United Church

Planning Consultation Response - Design Amendment

June 2026

title:  
Proposed Site & Roof Plan

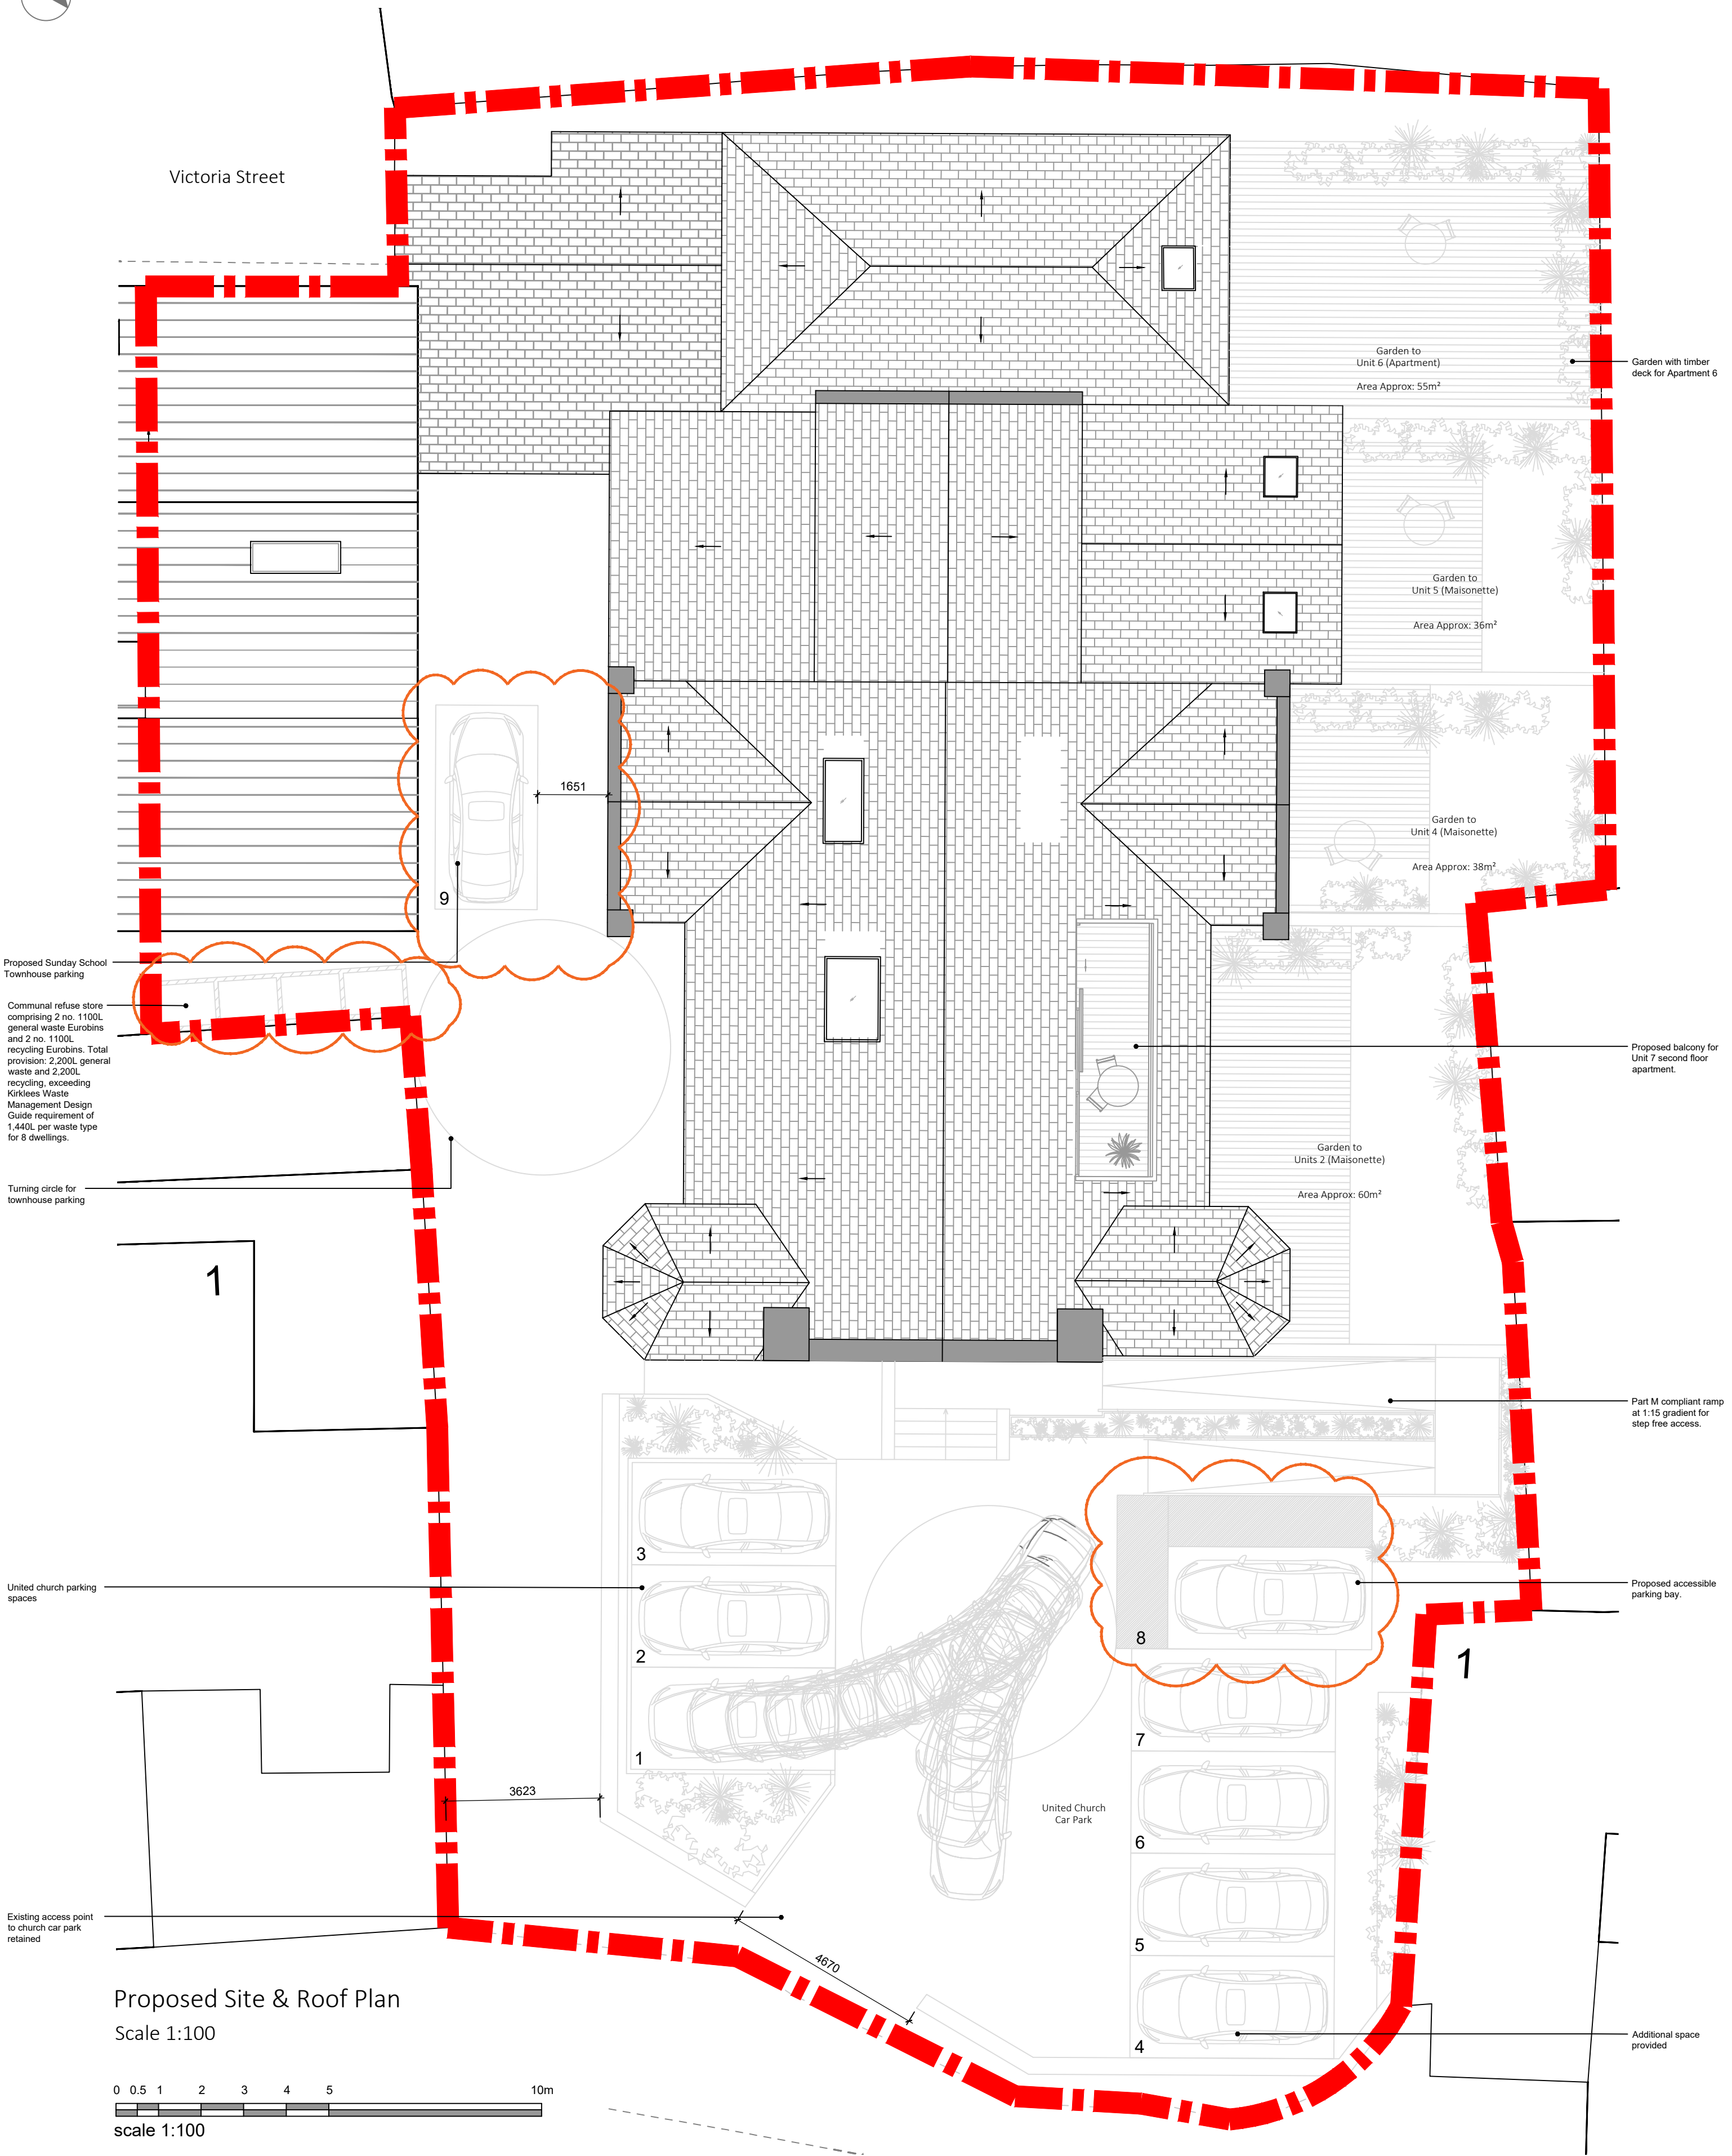
The proposed accessible parking bay has been reviewed and amended in response to comments received from the Local Highway Authority.

In addition, the balcony has been set within the roof pitch and the glass balustrade recessed within the roof opening to reduce visual prominence and address comments raised by the Conservation Officer.

The parking space has been enlarged to provide the required 1.2m side access aisle and 1.2m rear access aisle, improving accessibility and ensuring the parking arrangement better accommodates wheelchair users and those with reduced mobility.

Additional dimensions have been added to the site plan to clearly demonstrate the width of the vehicular and pedestrian access routes throughout the development.

title:
Proposed Second Floor Plan

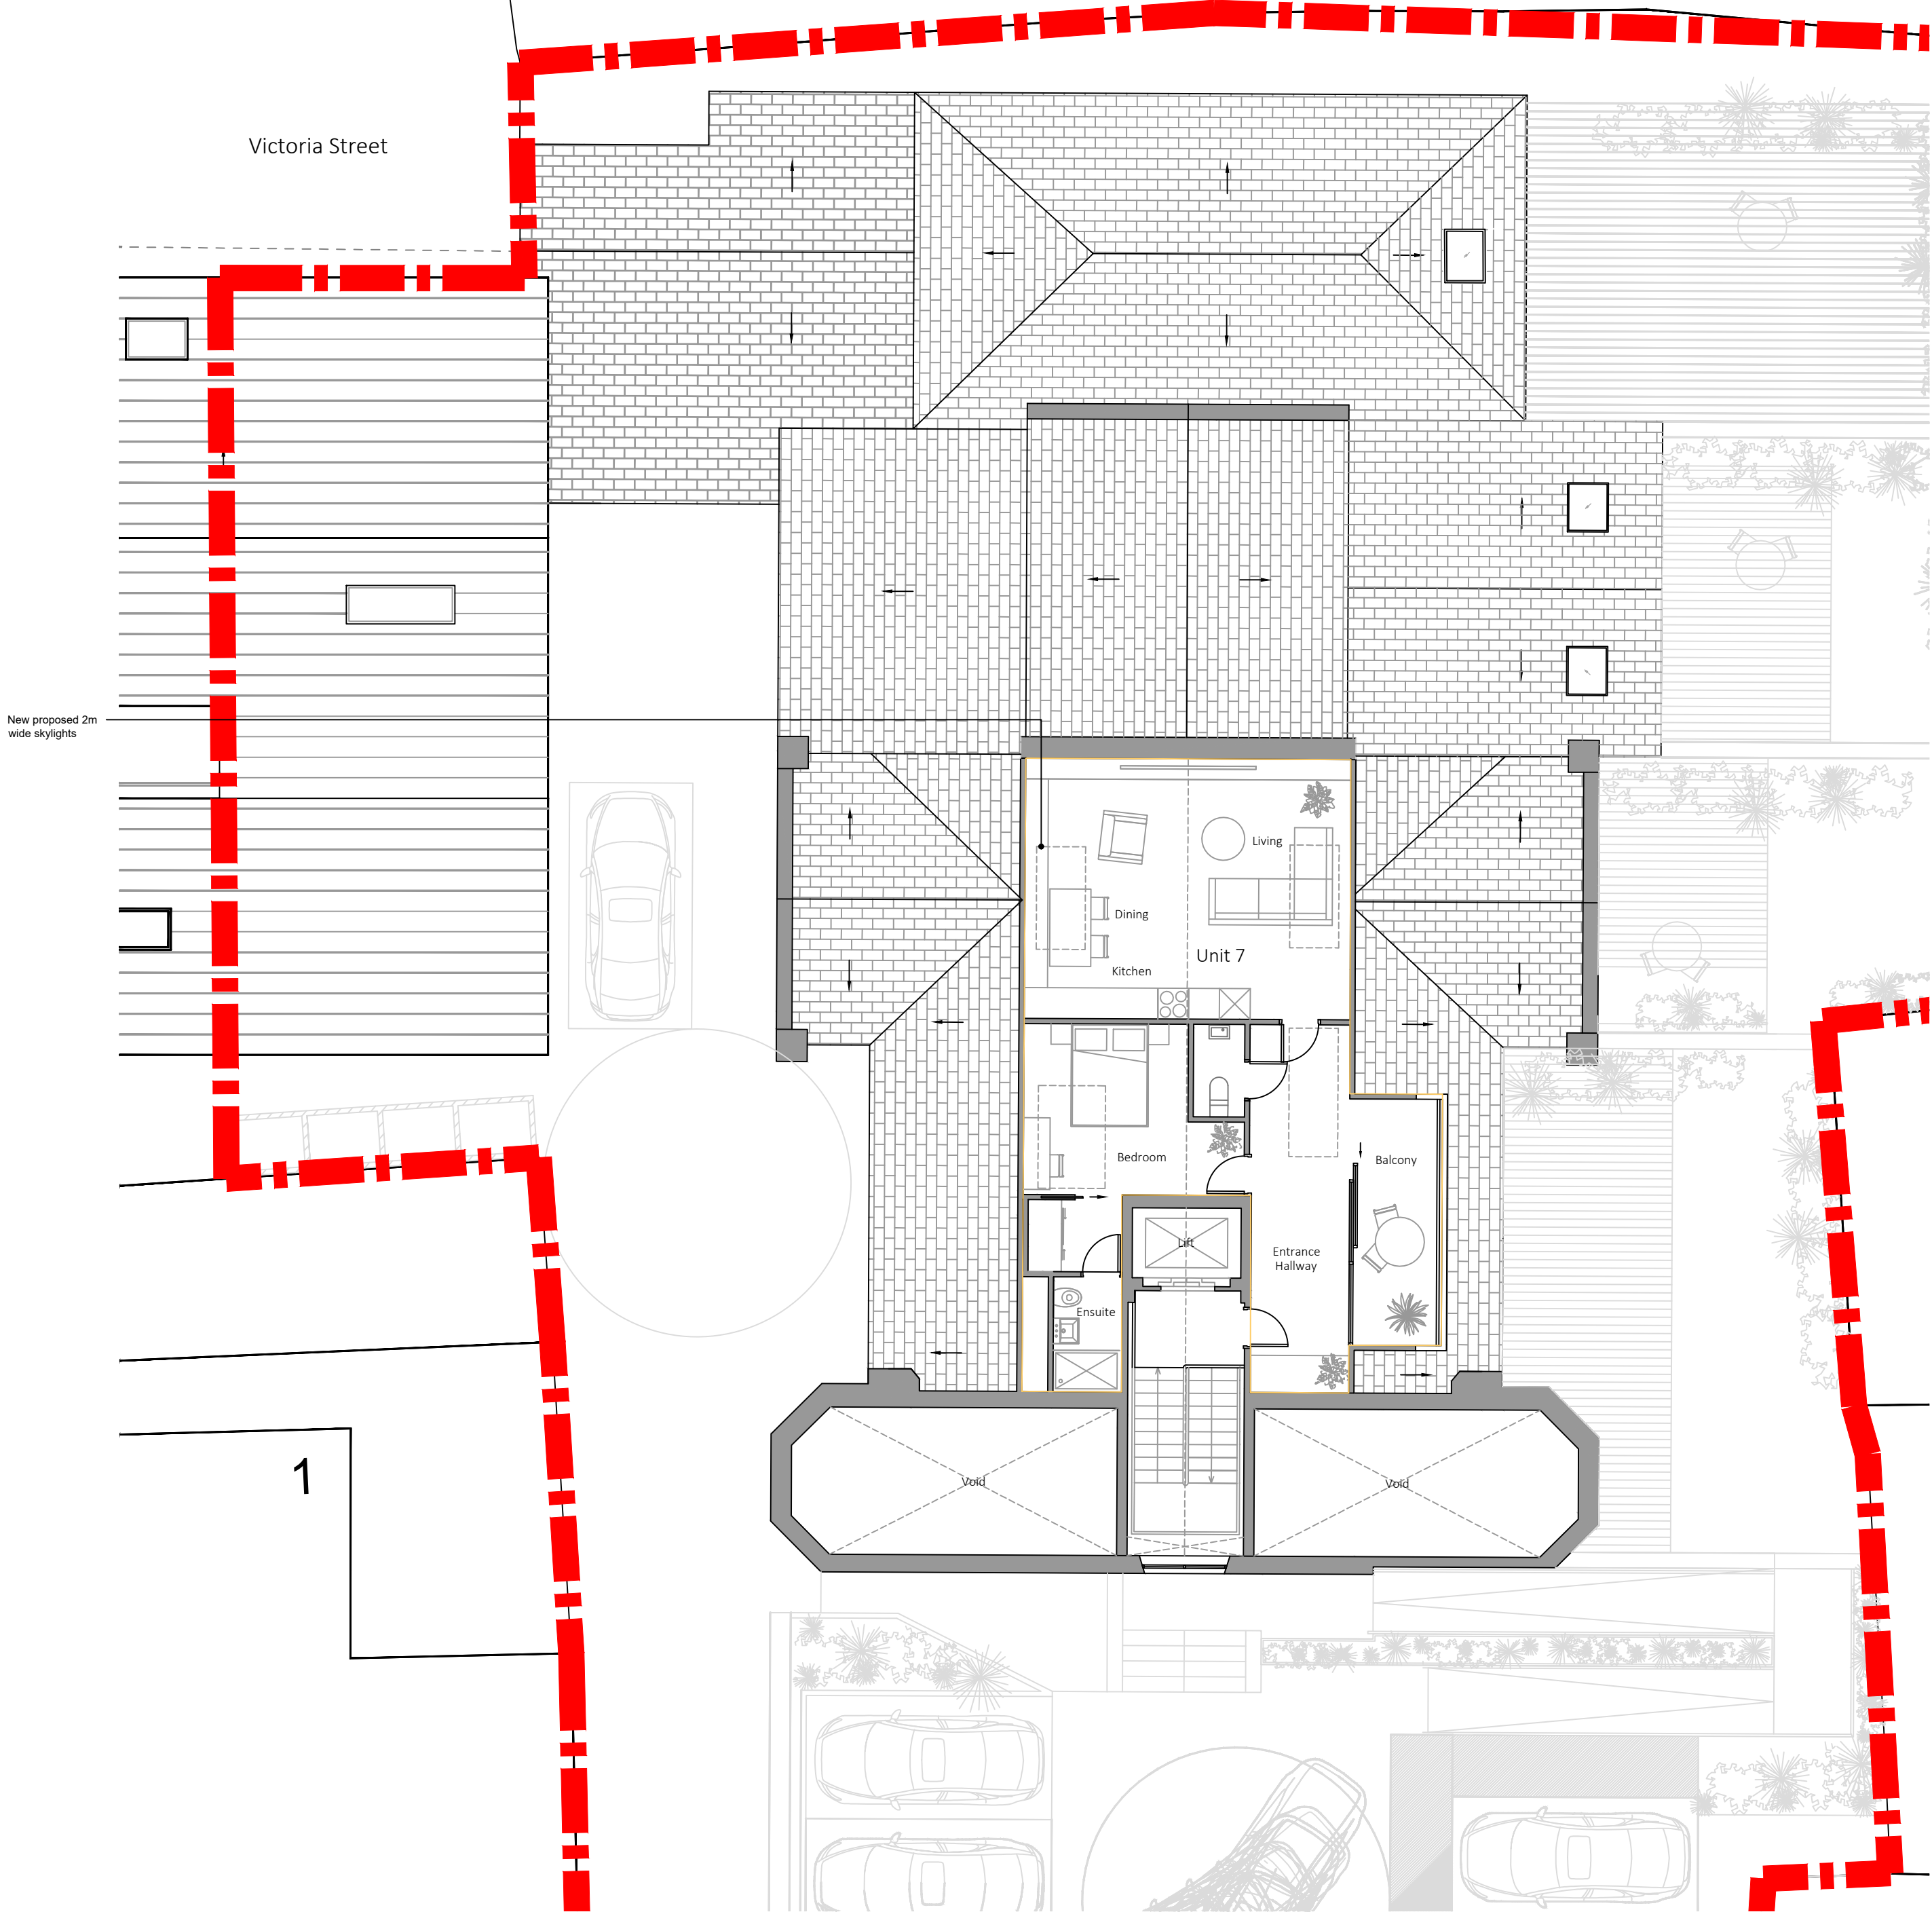
The Conservation Officer expressed concerns regarding the scale and prominence of the proposed rooflights.

The second floor layout has been amended accordingly to accommodate the revised rooflight arrangement.

title:
Proposed Ground Floor Plan

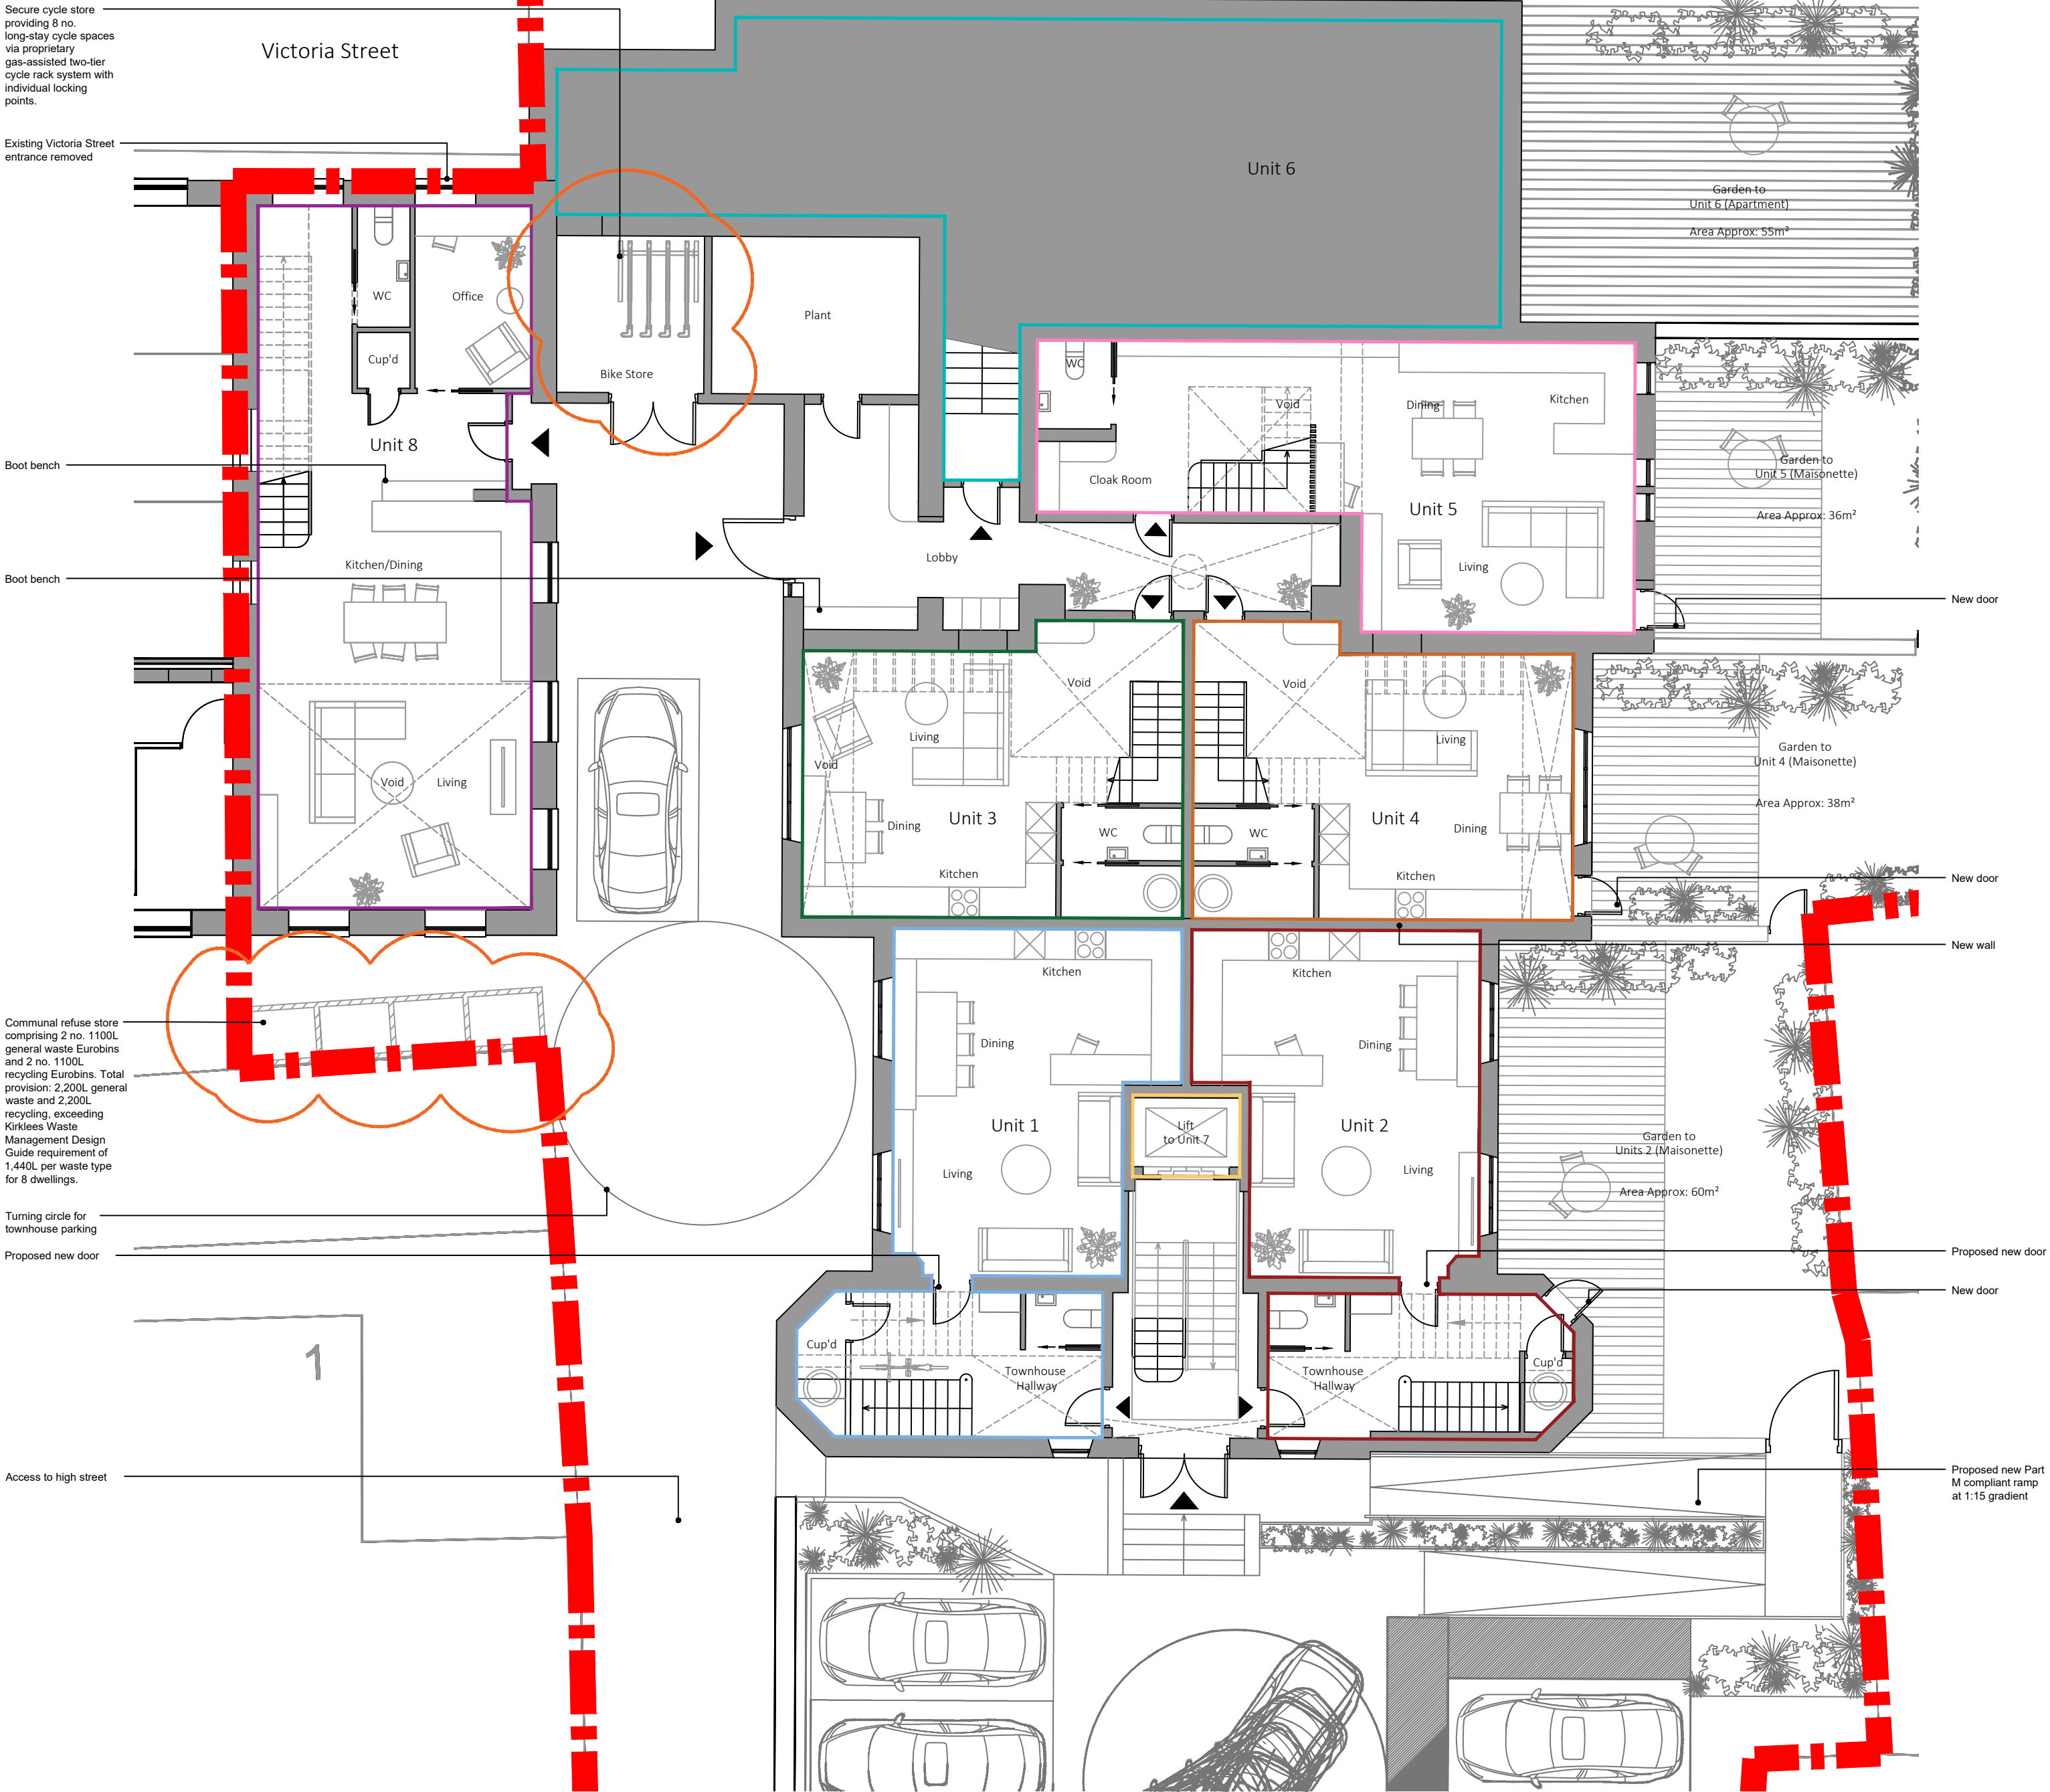
The original cycle store has been reviewed and updated to provide secure long-stay cycle storage for 8 bicycles, in accordance with the requirements of the Local Highway Authority.

The revised facility increases provision from 6 to 8 cycle spaces and addresses the requirements of the consultation response
